City of Albuquerque Stormwater Construction Site Inspection Report

General Information					
ESC File No.	M15E008		Project Name:	Wagoner Building	
NPDES Id. No.	NMR10051B/NMR10051C		Location:	1800 Randolph Rd SE	
5/28/2025	Owner		Contractor		
Operator	LOE Investments LLC		Eastley Inc.		
Contact name & title	Matt Wagoner		Matt Wagoner		
e-mail	matt@eastleyinc.com		matt@eastleyinc.com		
Contact Phone #	951-712-1394		951-712-1394		
COA Inspector	Chancellor English		Start/End Time:	11:45am	
Construction Phase:	Foundations				
Type of Inspection:	Regular	Storm Event	Post Storm Event >0.25"	311/Complaint	Follow Up
Weather at time of inspection?	Clear		Temperature:	~ 85	
Estimated date of last storm 0.25" or greater	5/4/2025

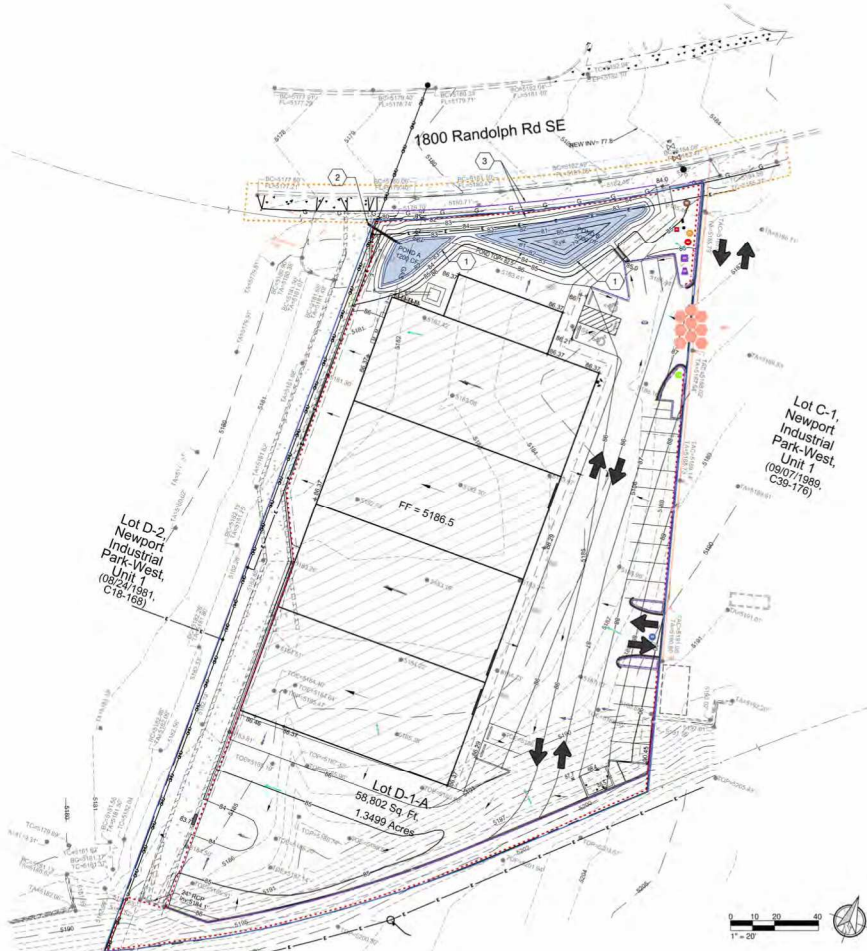
3	BMPs - The silt fence on the northeast corner has been taken down and needs to be re-installed in violation of CGP Part 2.1.2. Required mitigation: Design and install all stormwater controls in accordance with good engineering practices, including applicable design specifications per CGP Part 2.1.2.
